KIRKLEES METROPOLITAN COUNCIL INVESTMENT & REGENERATION SERVICE

DELEGATED DECISION TO DETERMINE PLANNING APPLICATIONS

Reference No:	2025/62/91020/E
Site Address:	108, Botany Lane, Lepton, Huddersfield, HD8 0NF
Description:	Erection of two storey side extension and single storey rear extension
Recommending Officer:	Faiza Bano

OFFICER REPORT

FRONT ELEVATION

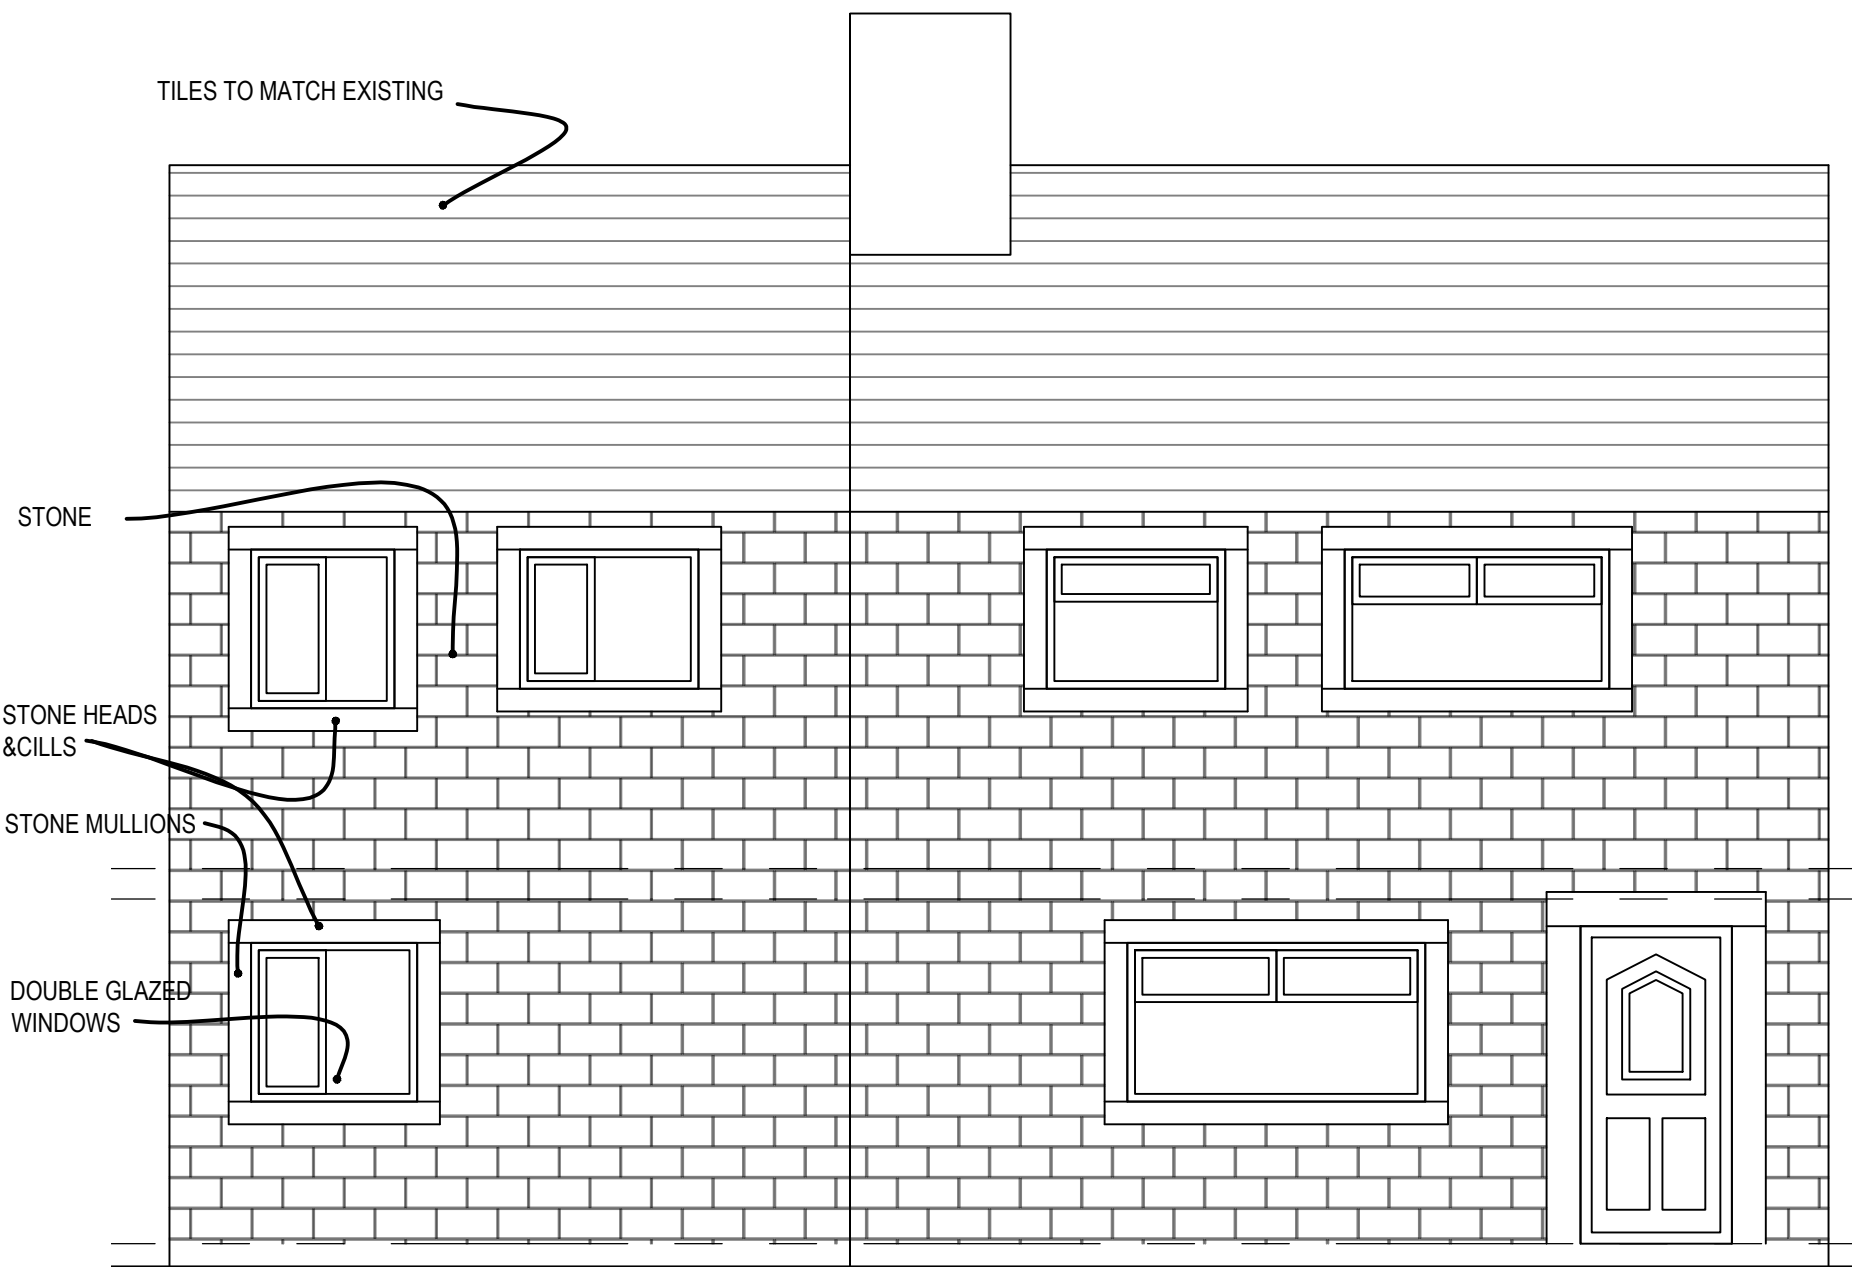
The proposed two-storey side extension projects beyond the footprint of the existing single-storey addition, resulting in an increase in overall bulk and massing. To address concerns regarding its visual impact and integration with the host dwelling, the scheme has been amended to include a reduction in height and a minimum 500mm setback from the principal front elevation. These changes ensure the extension reads as a subordinate addition, reducing its visual dominance and enhancing its relationship with the surrounding street scene.

The proposed plans originally included a rendered finish. However, in the interest of achieving visual harmony with the surrounding context, confirmation was sought regarding the applicant's willingness to apply a stone finish to the front and rear elevations.

The request for a stone finish to the front and rear elevations is intended to ensure the proposed development integrates more sensitively with its surrounding context. Stone is a predominant material within the local streetscape and wider area, contributing to a consistent and visually cohesive character. By aligning the external treatment of the proposal with this established palette, the development will better respect local vernacular

To achieve this, the side extension now includes a 500mm set back from the front elevation and a reduced ridge height, helping to reduce its overall mass and visual dominance. While the ridge could not be lowered further without compromising the roof pitch and visual harmony with the host dwelling, the current design is considered to strike an appropriate balance.

3. The external stone facing materials for the front elevation and roofing materials of the extension hereby approved shall in all respects match those on the existing building. The render shall be a natural stone colour. The materials shall be thereafter retained in accordance with the amended plan.

PROPOSED SIDE ELEVATION

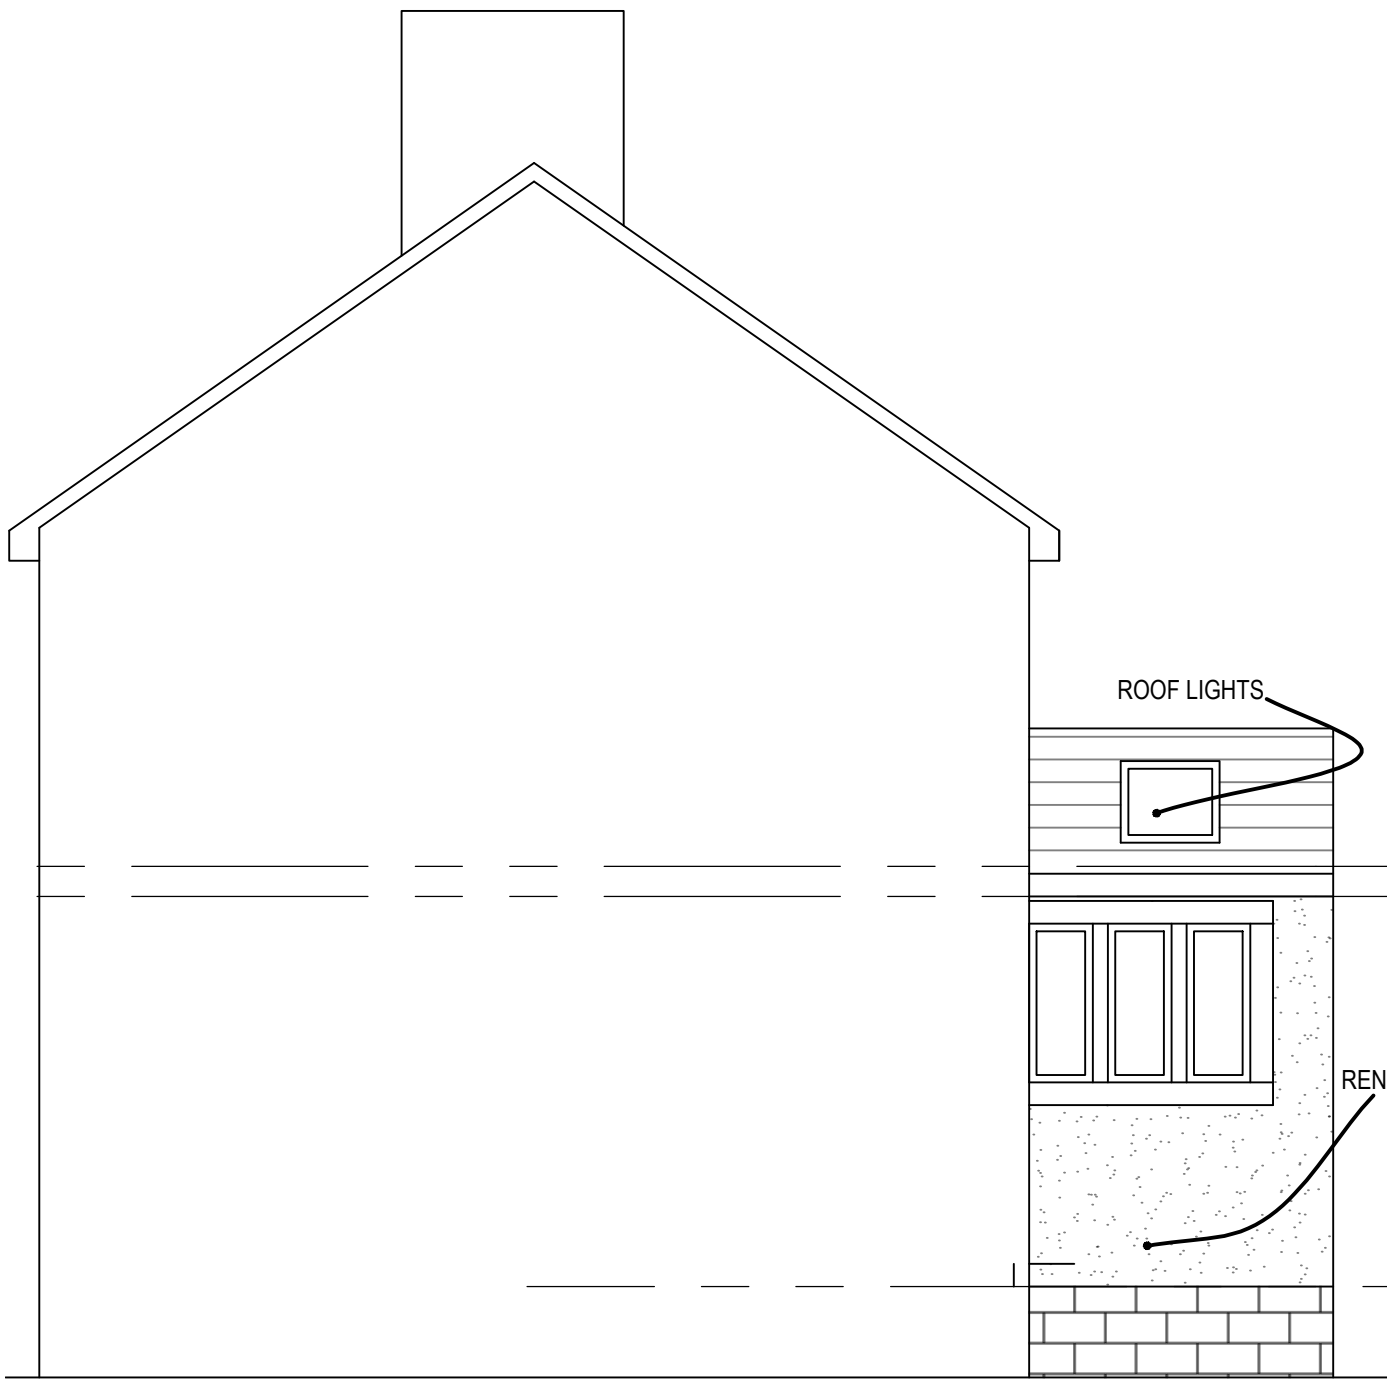
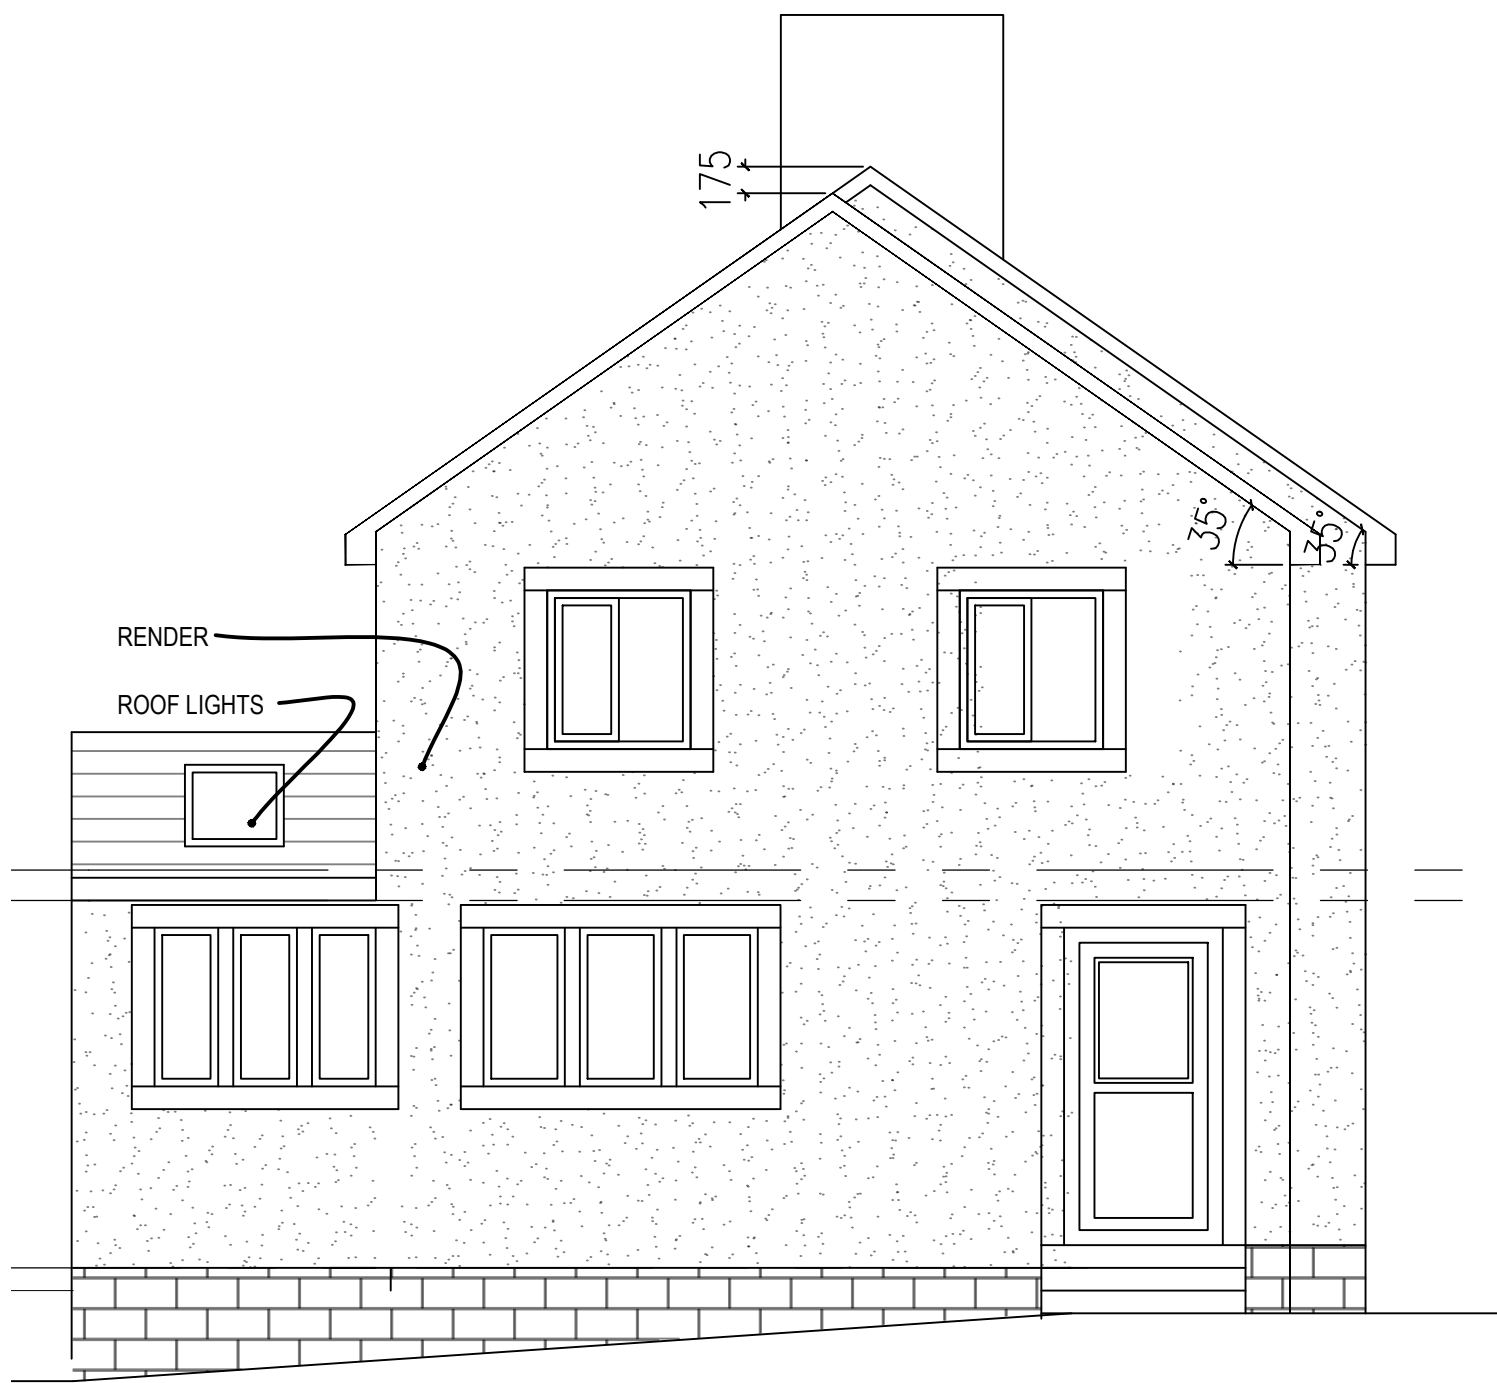
- Extensions should be subservient to the host dwelling (Policy LP24 and House Extensions & Alterations SPD).
- The cumulative impact of previous extensions, including a detached garage, was a concern.
- The scale and massing of the side extension appeared dominant.
- A 500mm set back and lower ridge line were recommended to reduce visual impact and ensure subservience.
- The rear single-storey projection was considered acceptable, subject to the above amendments.

- The side extension amended to include a 500mm set back from the front wall of the original dwelling.
- The ridge height of the extension was reduced in line with the set back to improve subservience.
- It was noted that further reduction to the ridge height was not feasible without altering the roof pitch, which would negatively affect the appearance in relation to the host dwelling.

PROPOSED REAR ELEVATION

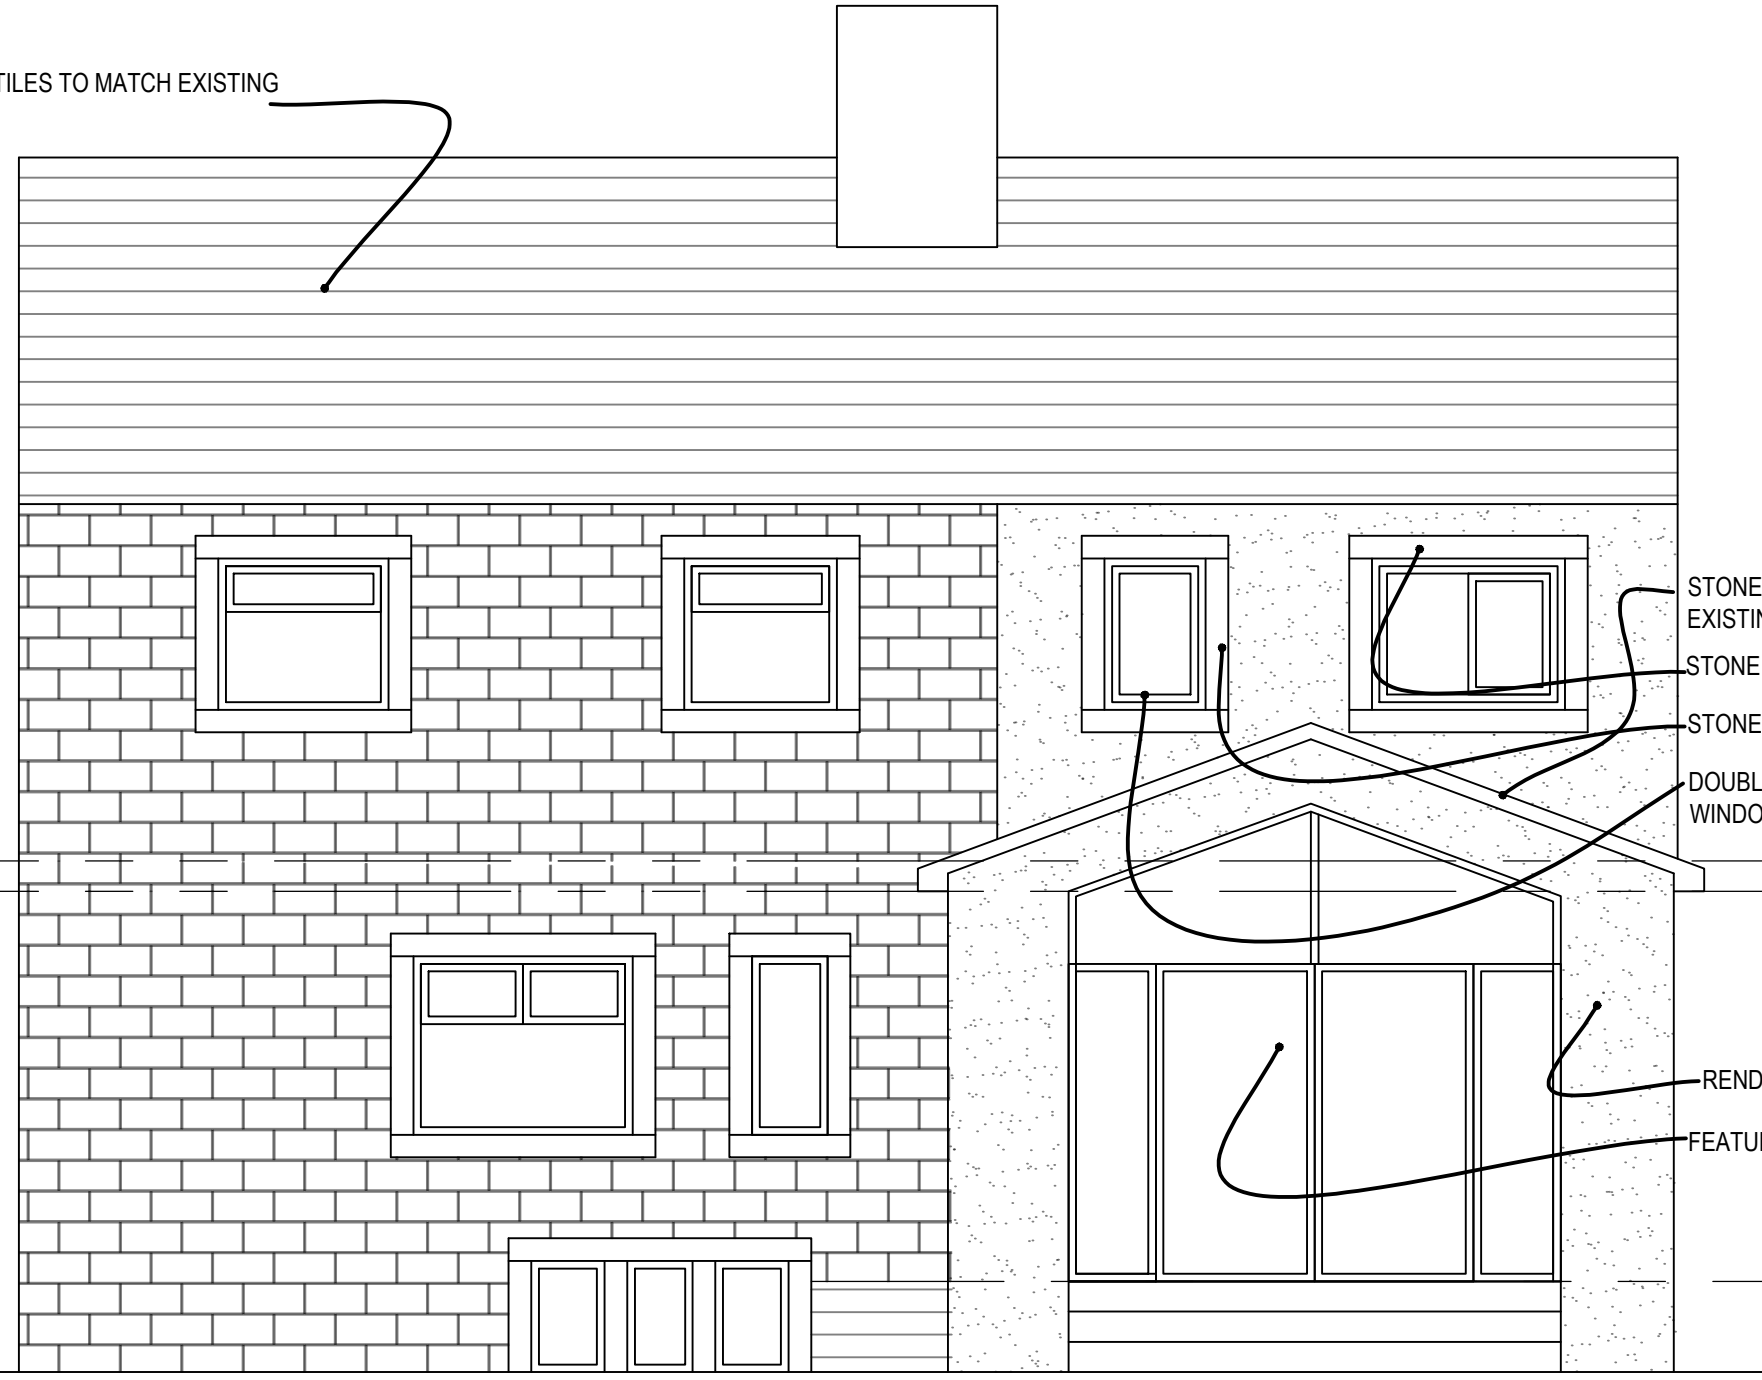
The single storey rear extension projects out by 2m and spans a width of 4.8m, with an eaves height of 2.6m. The extension is designed with a pitched roof and is not considered to have any impact on neighbouring properties. The proposal aligns with the guidance set out in the SPD.
